**PLANNING DEPARTMENT
DEVELOPMENT SERVICES DIVISION
600 2nd Street NW, Ground Floor, 87102
P.O. Box 1293, Albuquerque, NM 87103
Office (505) 924-3946**

OFFICIAL NOTIFICATION OF DECISION

Project# PR-2019-002874
Application#
SD-2024-00024 PRELIMINARY/FINAL PLAT

**TRACT C, COTTONWOOD POINTE
SUBDIVISION** zoned **MX-M**, located at **9651
EAGLE RANCH BLVD NW between IRVING
BLVD and WESTSIDE DRIVE** containing
approximately **6.771** acre(s). **(B-13)**

LANDSCAPE EXHIBIT WITH TREE WELLS
 EAGLE VISTA, LLC
 EAGLE RANCH RETAIL
 PROJECT NUMBER: 229023-A000280 DRAWING FILE NAME: 229023-A000280.00-CX-GD00 SCALE: 1"=30'

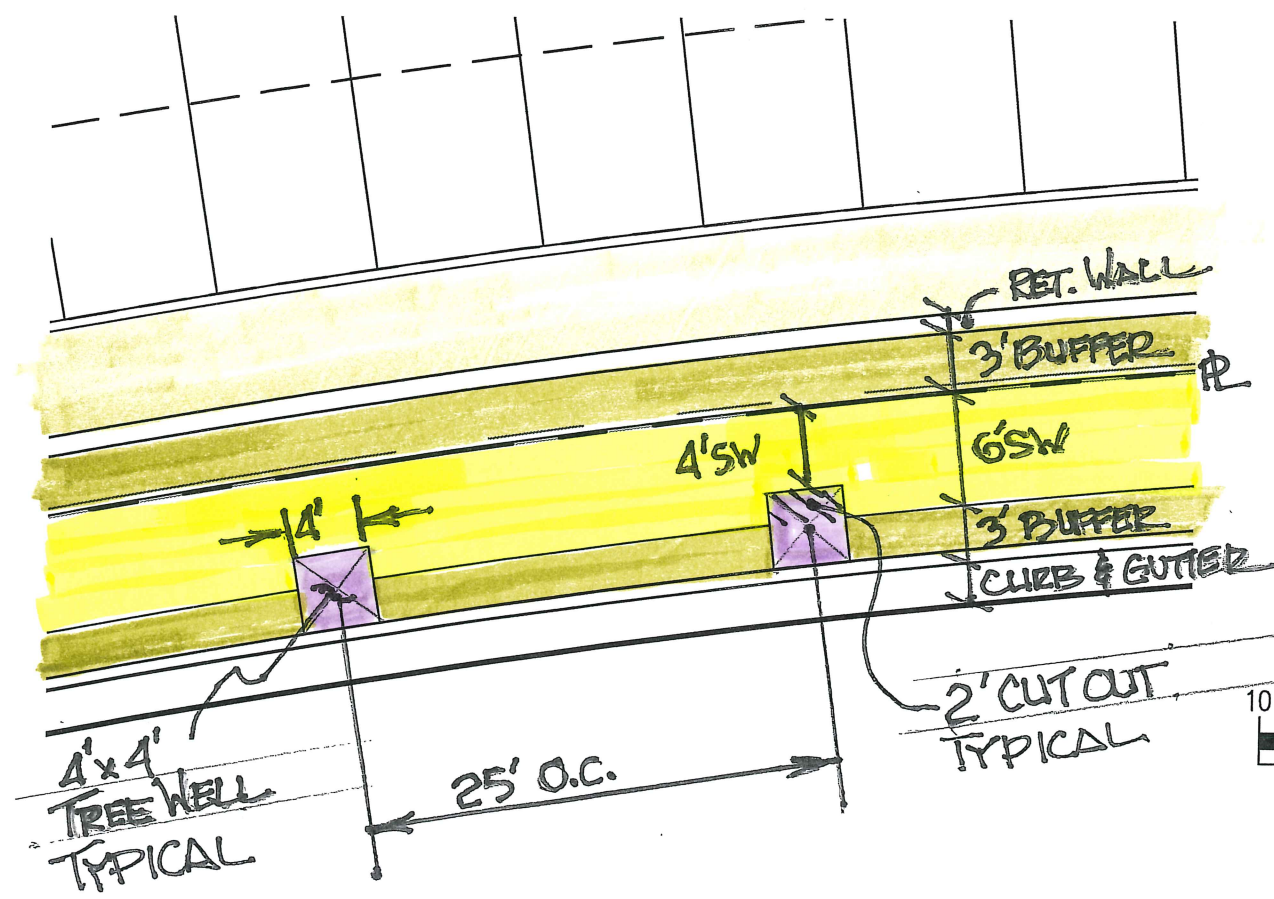
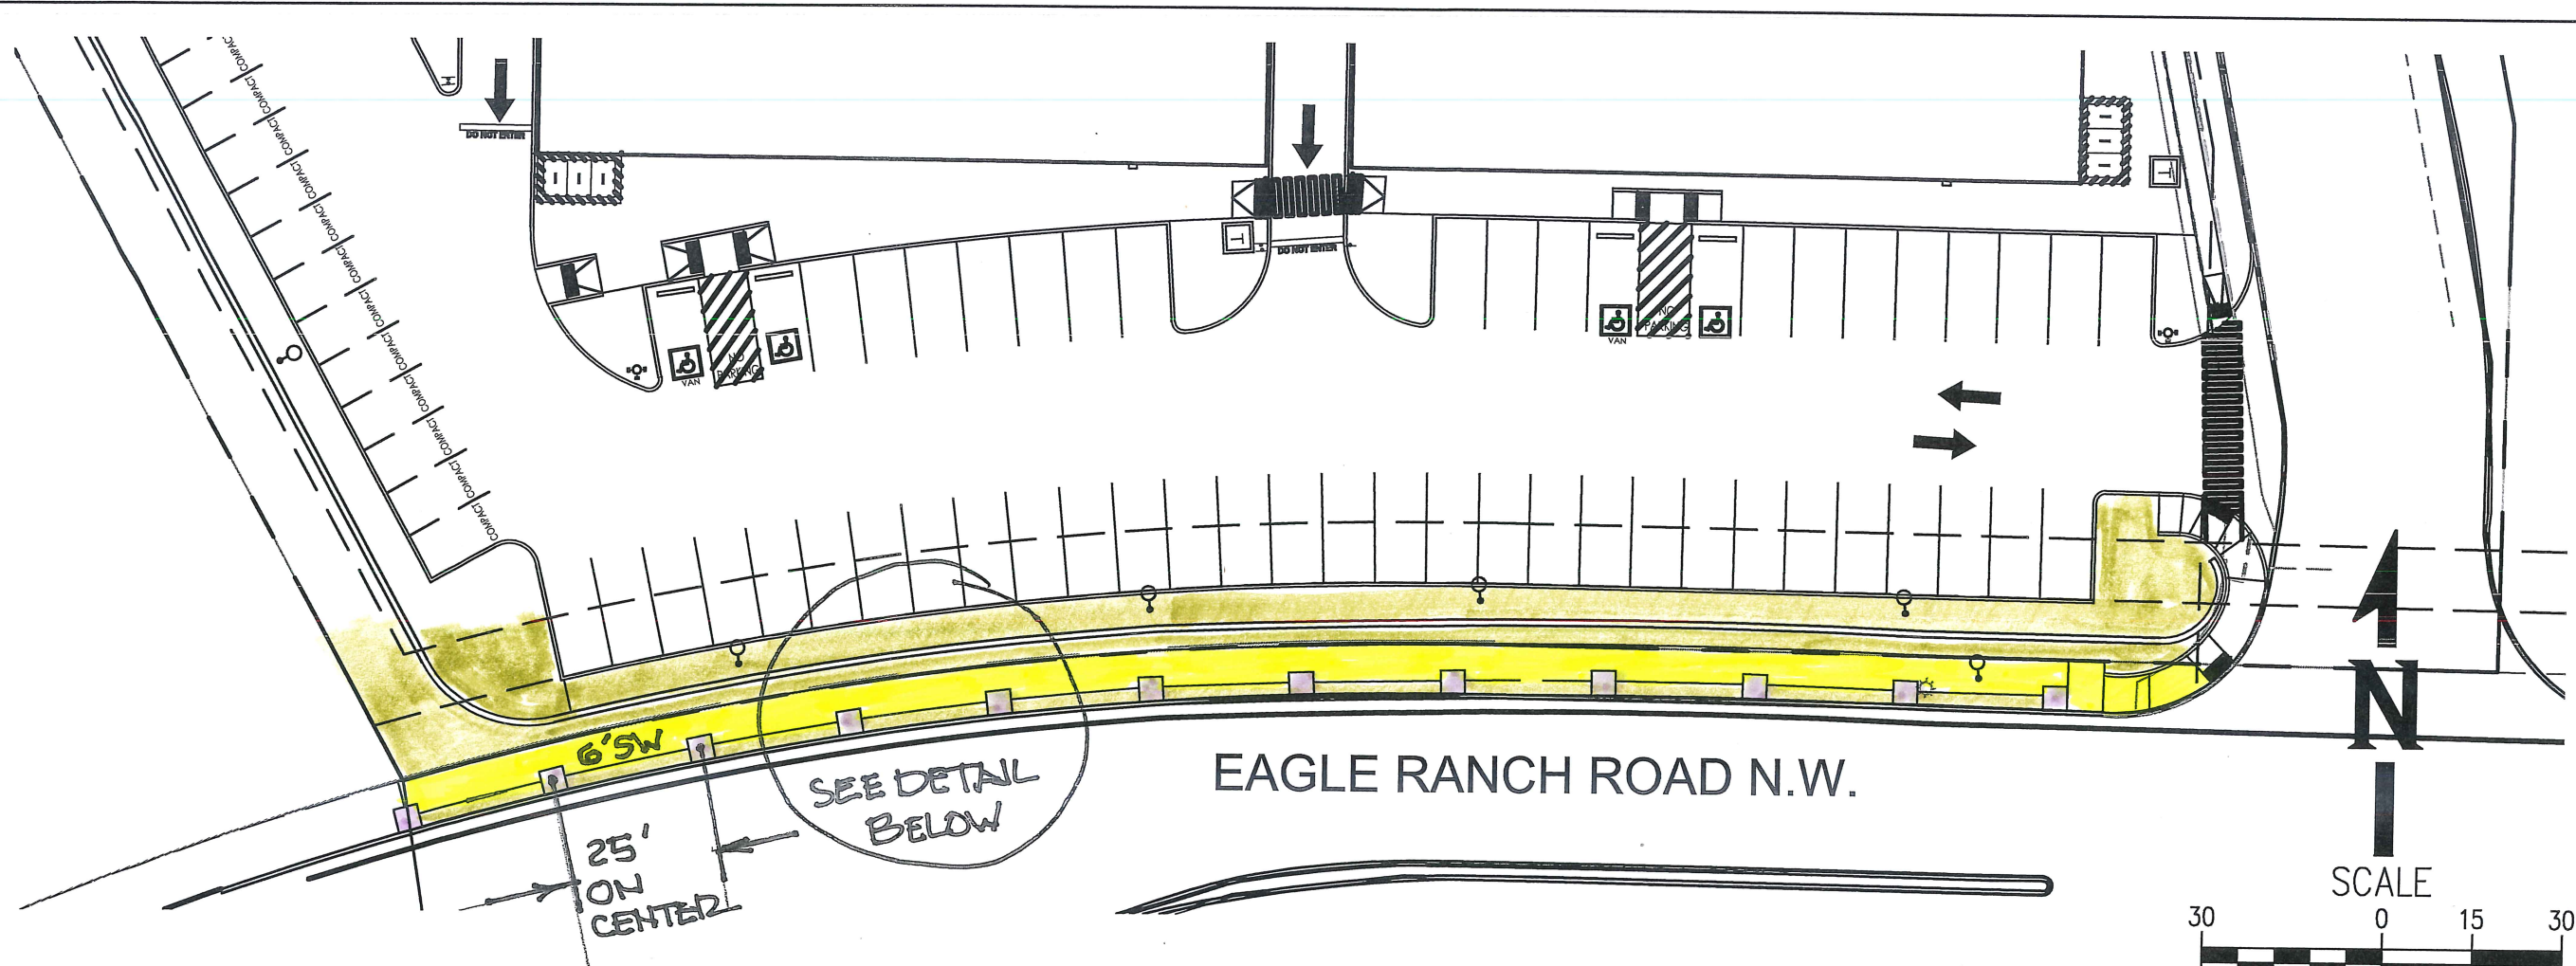
4. A Determination request for the landscape/buffer zone along Eagle Ranch Road NW to remain at its existing width of 3-feet was submitted with this Preliminary/Final Plat, is consistent with the existing sidewalk and landscape/buffer zone placement on the previously developed site abutting the northern boundary of the subject property along Eagle Ranch Road NW, and was approved and amended to include trees to be planted 25-feet on center along the sidewalk on Eagle Ranch Road by creating 2-foot cut-outs within the 6-foot sidewalk.
